Project: EP-27-0014 Schmidt PUD Preliminary Plan

El Paso County File Number: PUDSP264

Colorado Geological Survey (CGS) Review Comments

As requested in El Paso County's email dated August 19, 2026, the Colorado Geological Survey (CGS) reviewed the Schmidt PUD Preliminary Plan submittal, (File Number PUDSP264, located 38.9571, -104.6955) including Entech Engineering, Inc.'s June 19, 2026 *Soils and Geology Study*, All Terrain Engineering LLC's June 2026 *Master Development Drainage Plan/Preliminary Drainage Report*, the Letter of Intent, and the development plans.

DP1.00
1 OF 37

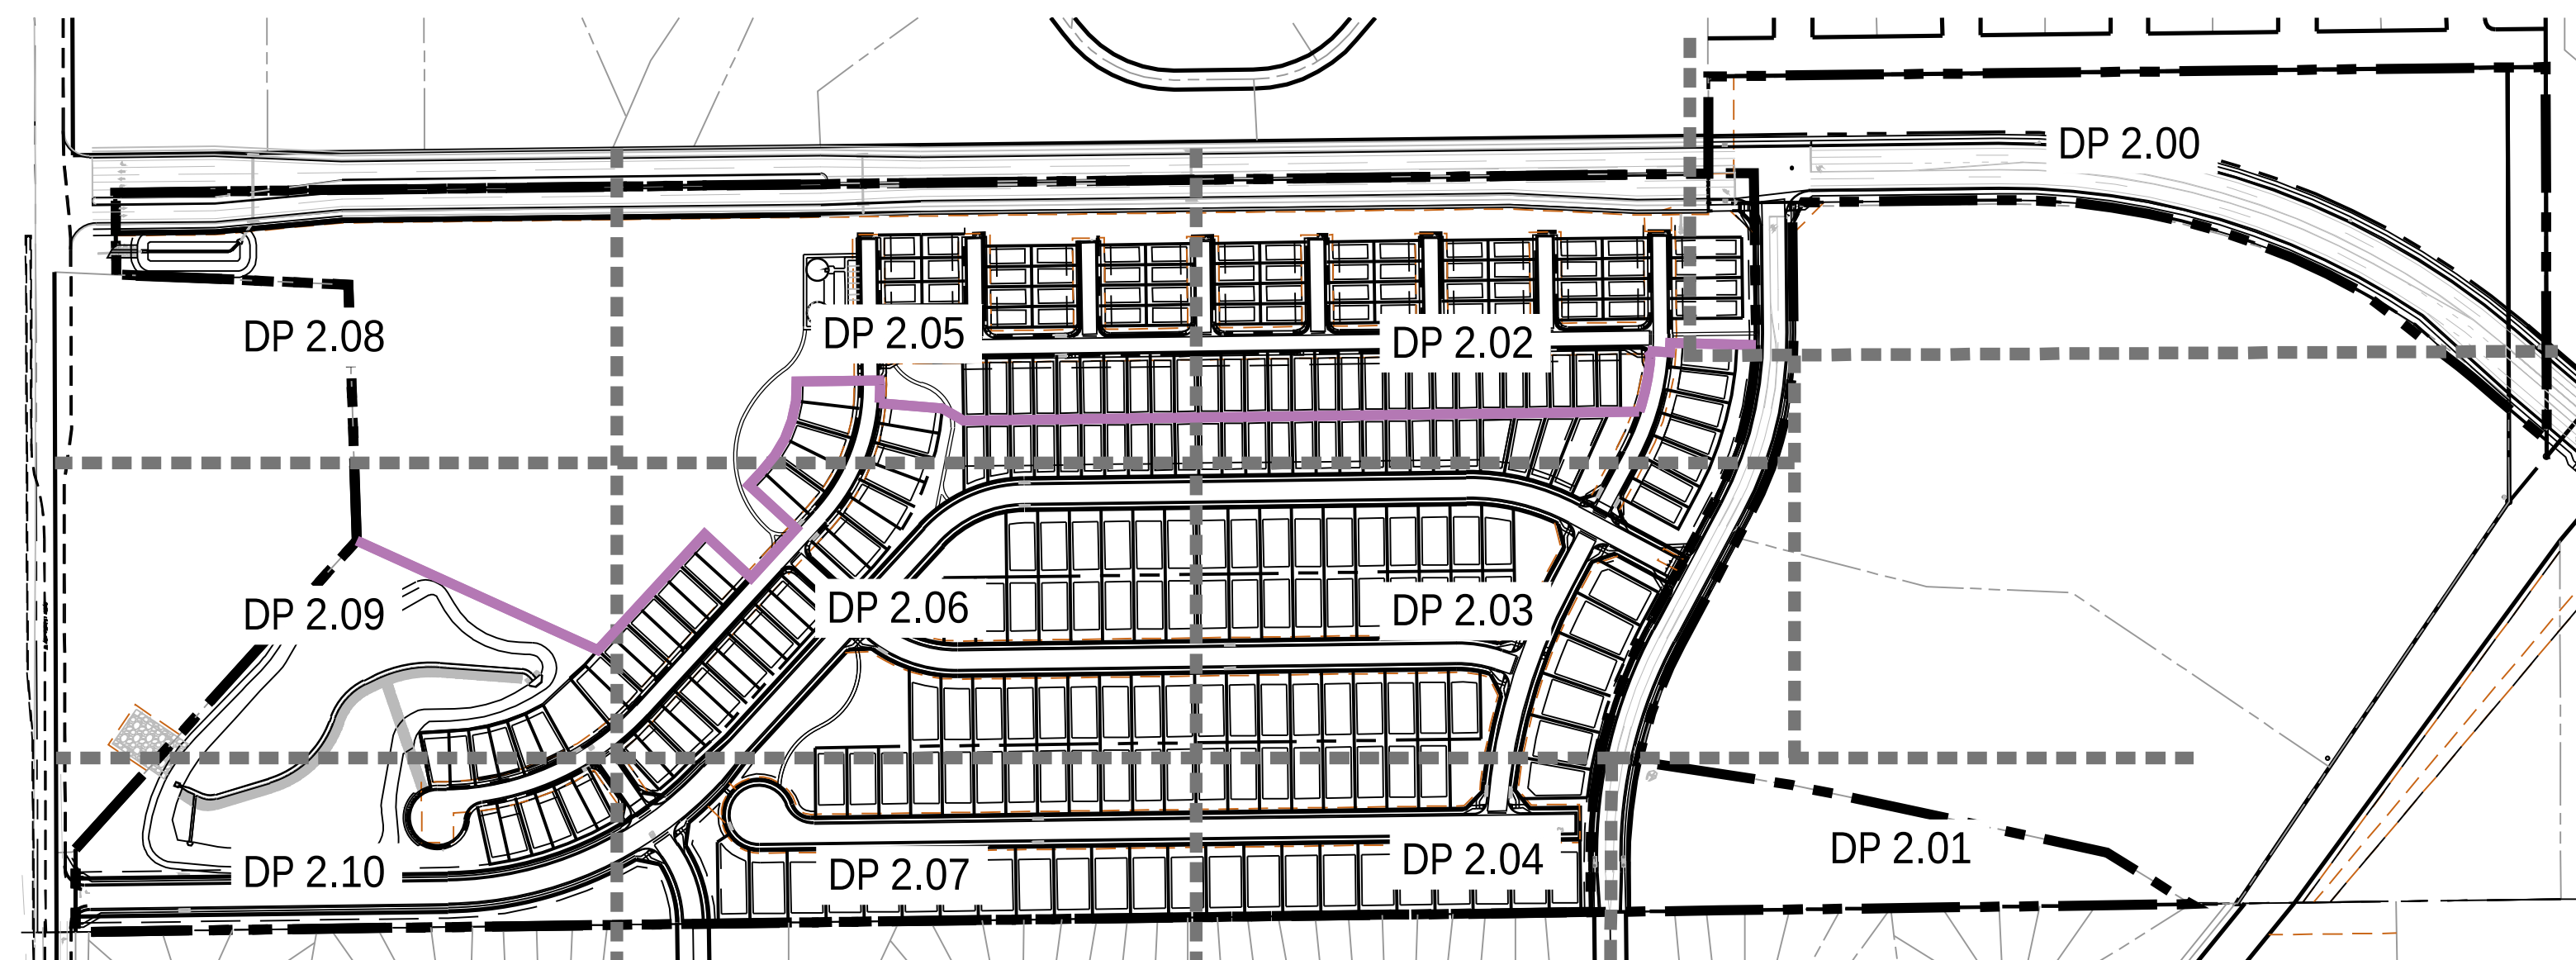
- **Correct the geohazard note.** Revise Sheet DP1.00 to reference Entech’s June 19, 2026 report, supplemental findings, applicable recommendations, and resulting development restrictions, with a reference to the County project file. State groundwater separation and floodplain criteria separately.
